DECISION DELEGATED TO HEAD OF PLANNING

Application No: H11-0516-22 **Applicant:** API Ltd.

Proposal: Details of brick for external walls & roof, window frames, external doors & door frames, roof lights and position of external meter boxes, gas flues & soil vent pipes (Conditions 4, 5, 6, 8, 9 & 12 of H11-1008-21)

Location: Adderley House, Stable Block 23 London Road Long Sutton

LEFT GABLE ELEVATION @ 1:100

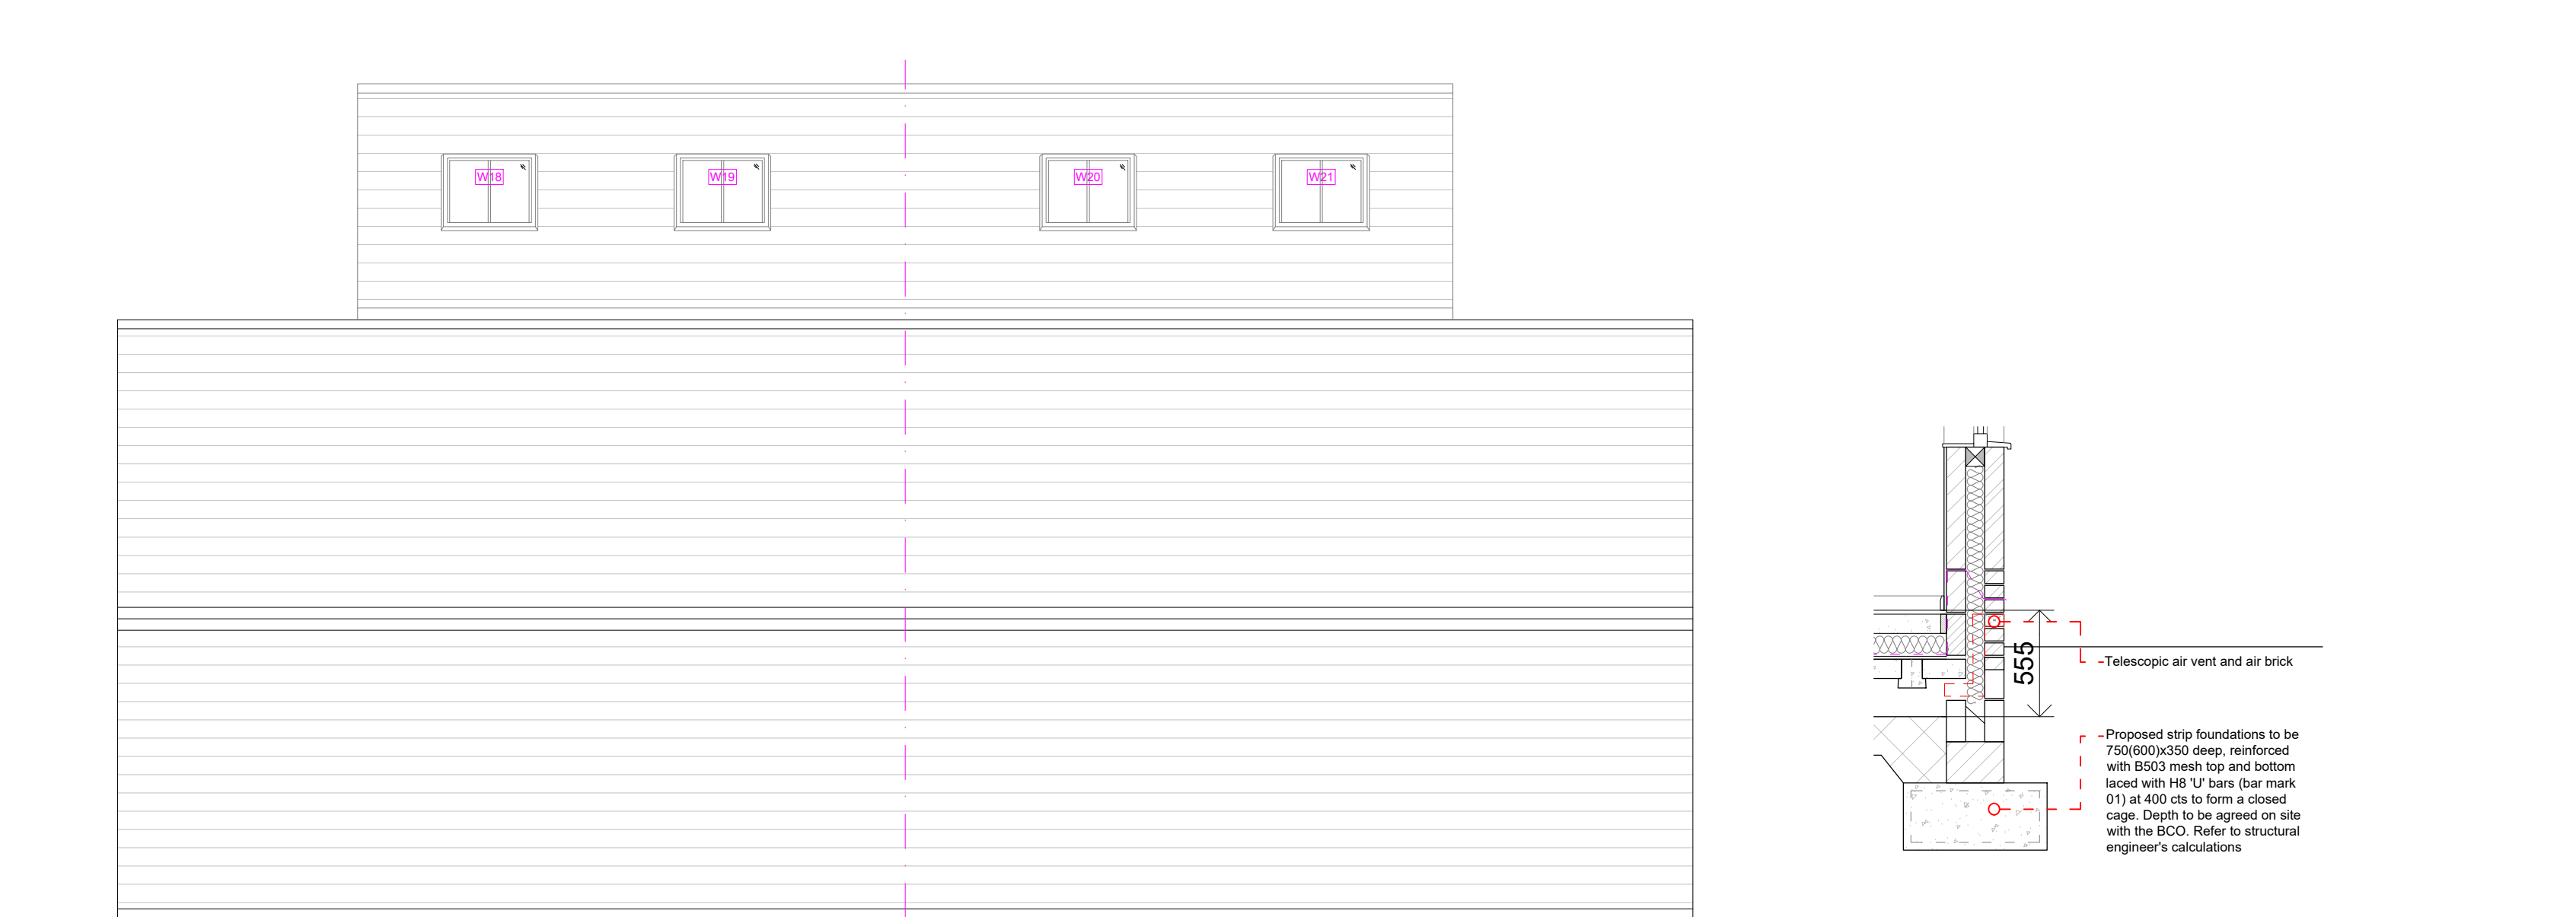
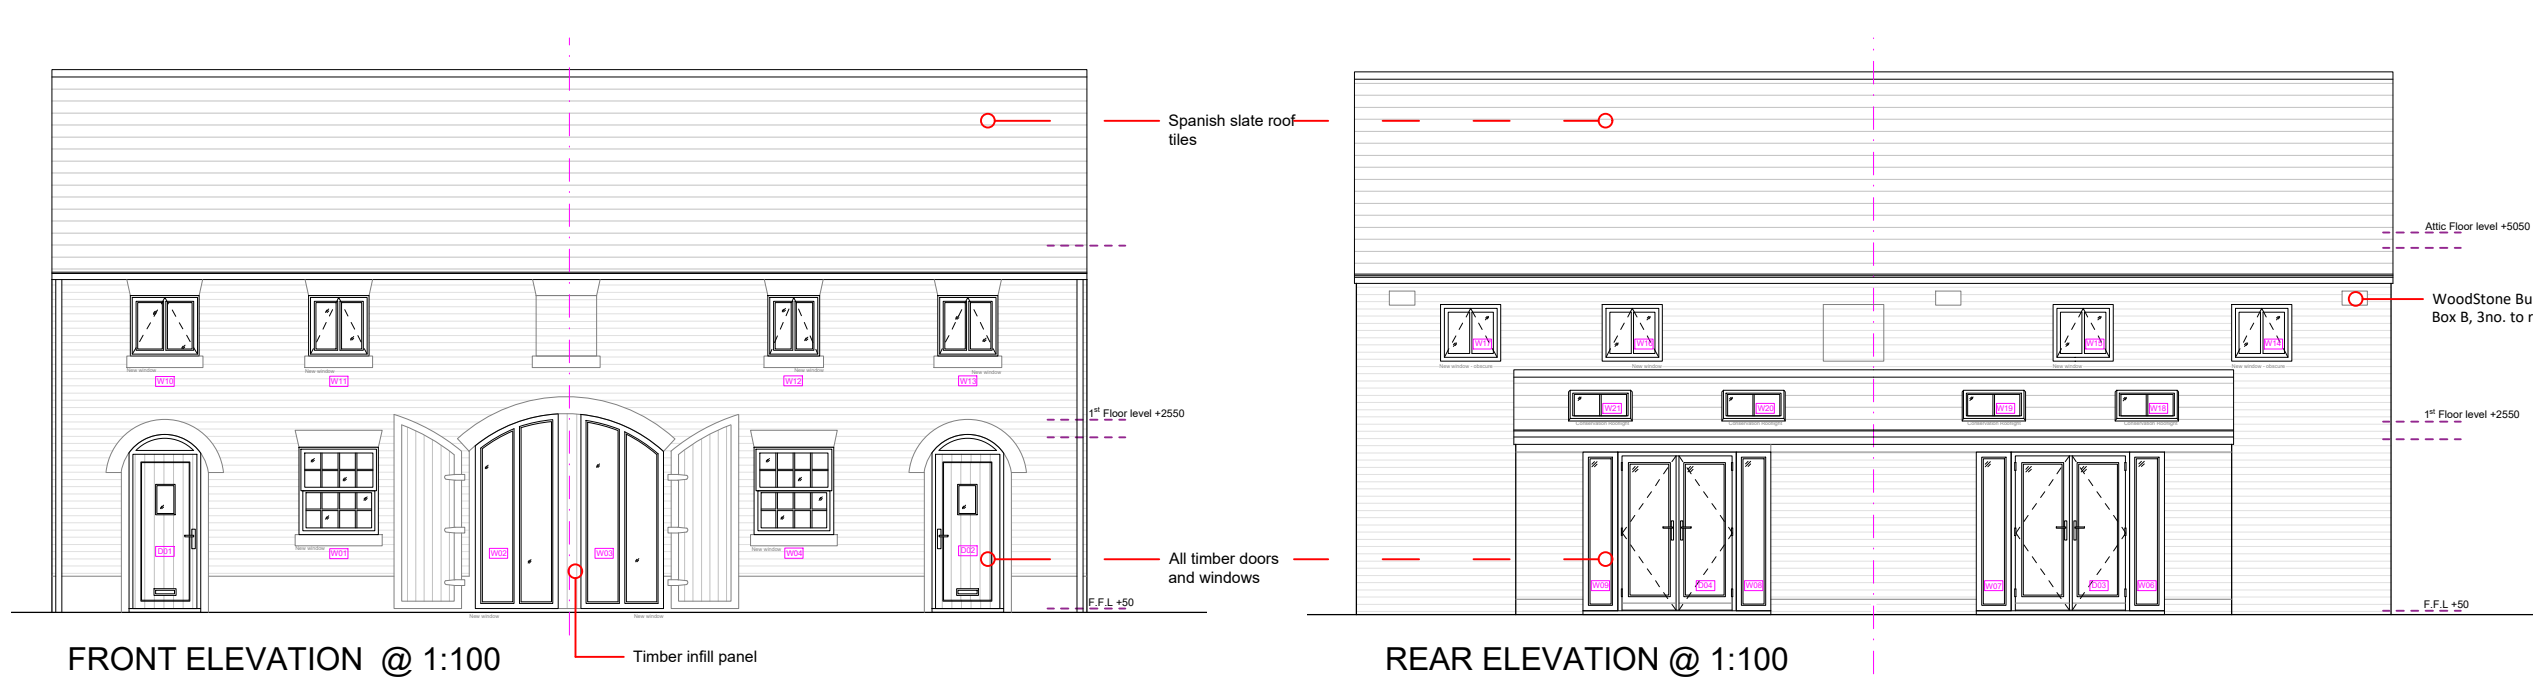
Condition 6 (Window details) - Condition 7 stipulates timber windows. Four types of window are to be installed (ie, stable, fixed, sash and casement) as per the approved drawings. The details are considered acceptable.

Condition 8 (Door details) - Condition 8 stipulates that the doors be constructed in timber. The submitted details are satisfactory.

Condition 12 (External boxes and domestic accoutrements) - External boxes would be installed on the side elevations and would be floor mounted.

ROOF PLAN @ 1:50

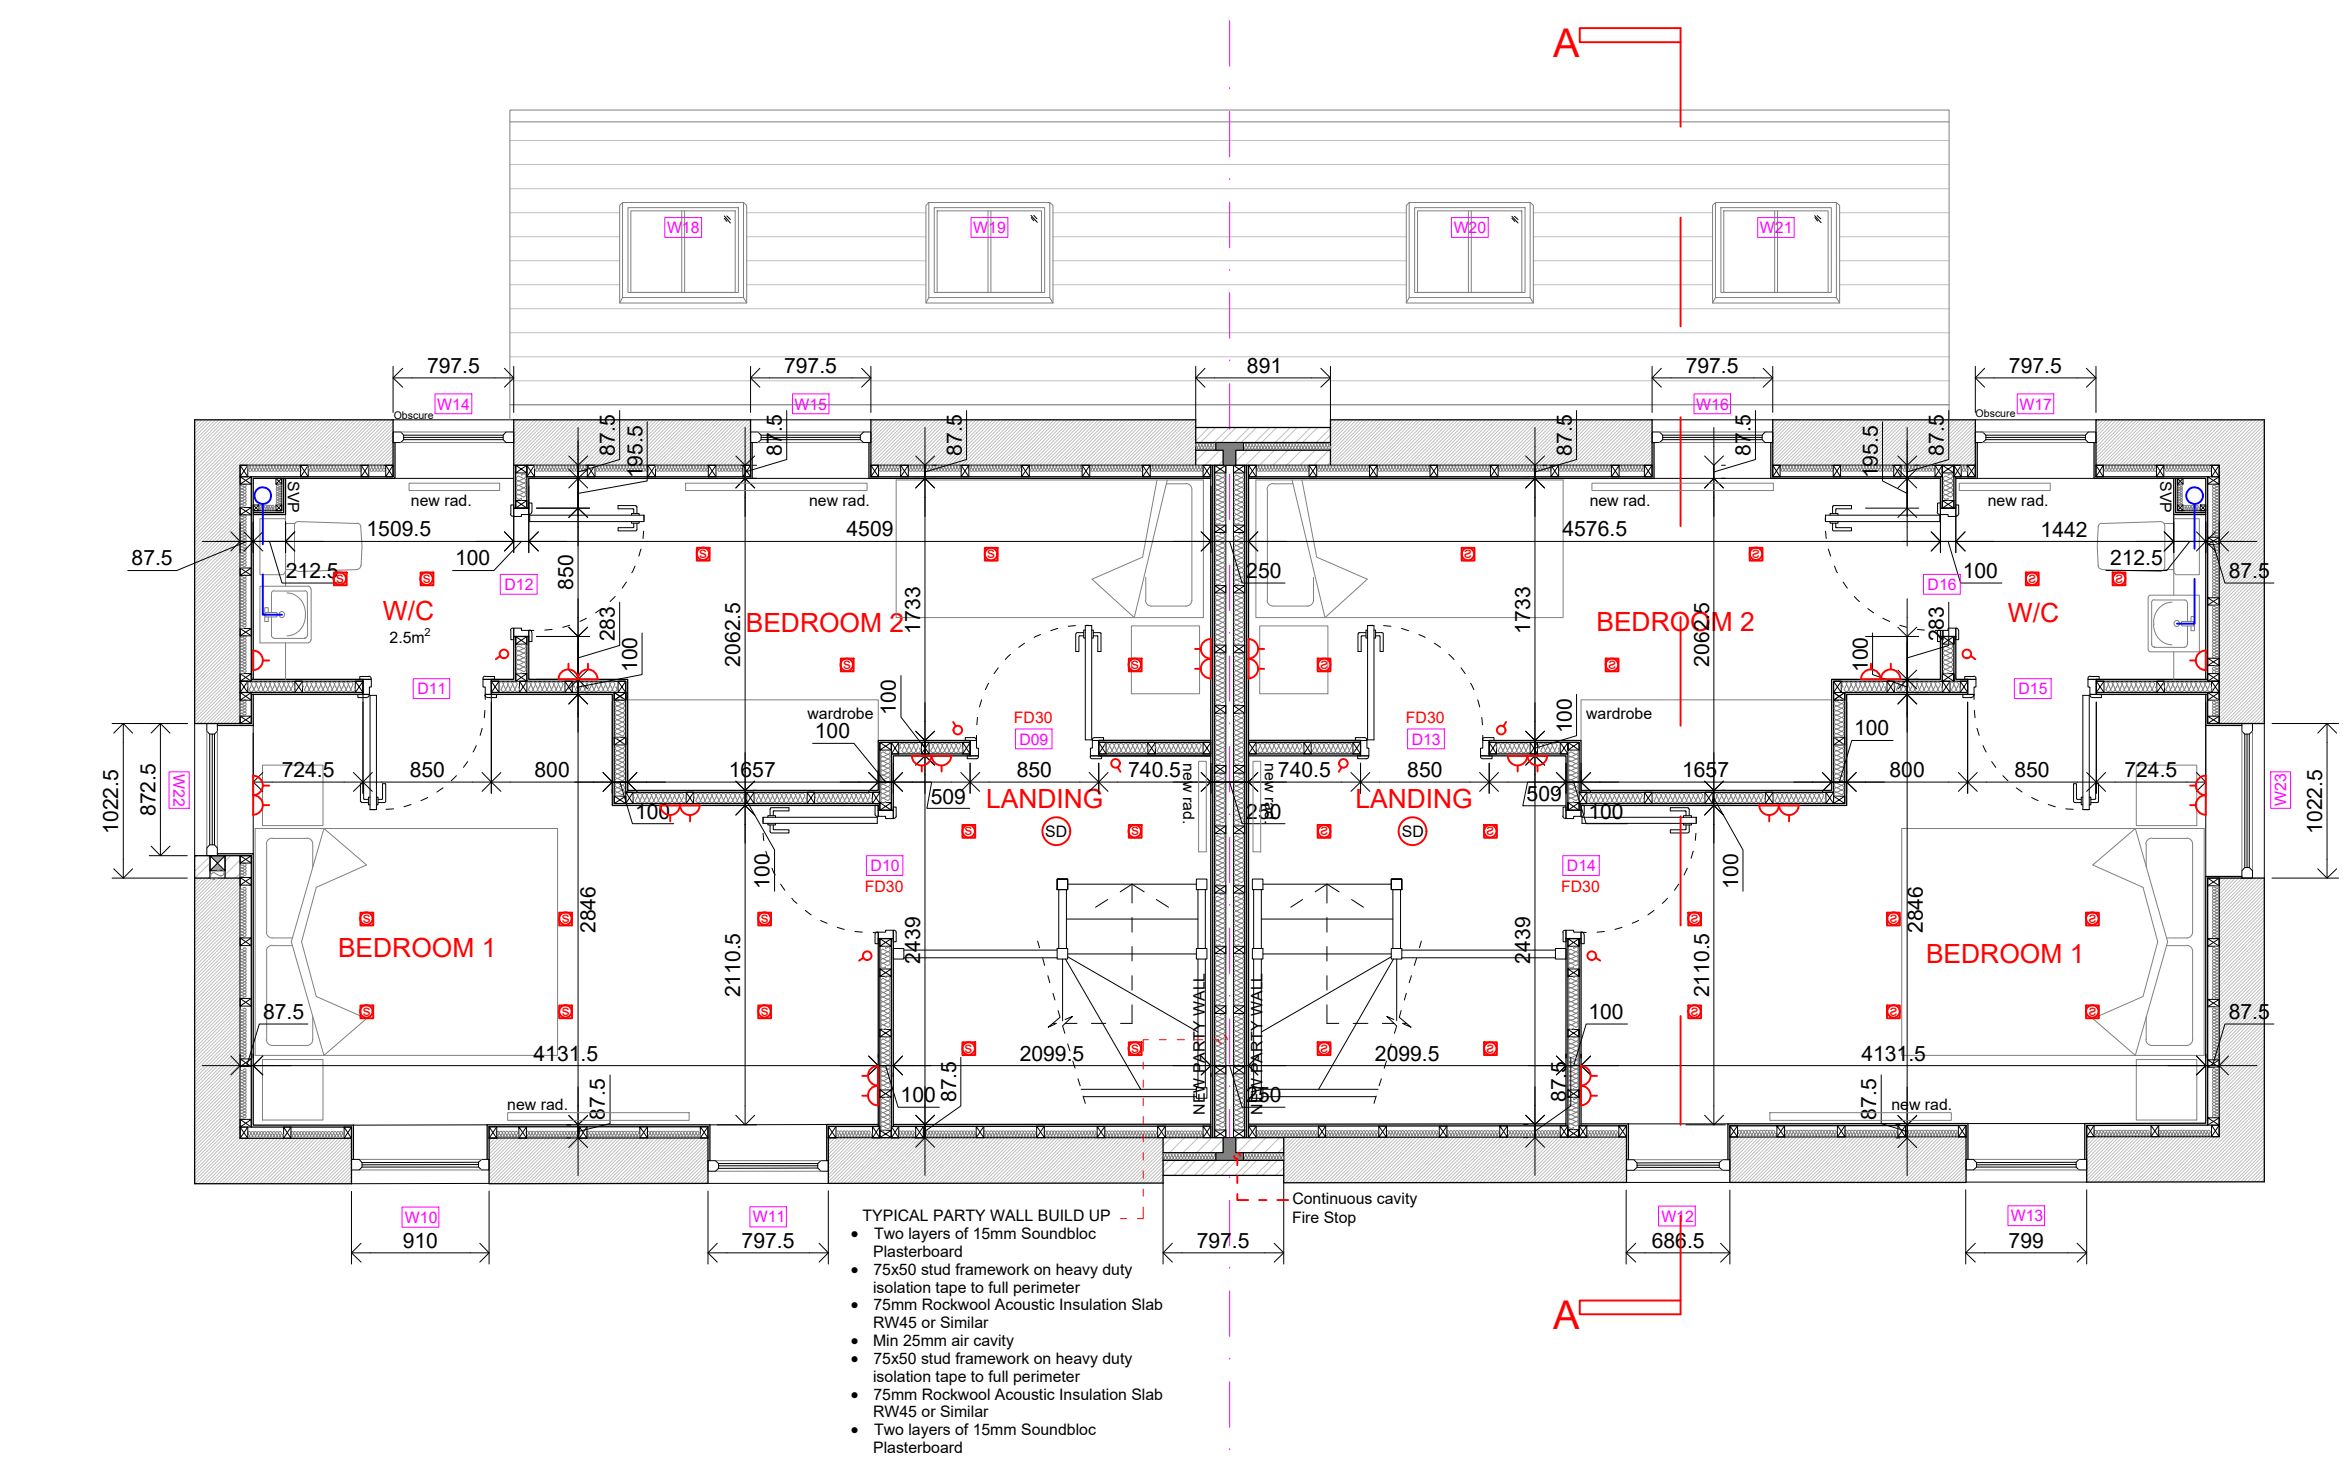
Condition 5 (Details of roofing material) - Spanish slate will be used for the external roof.

Condition 9 (Roof lights) - Conservation roof light swill be installed, which are considered to be acceptable.
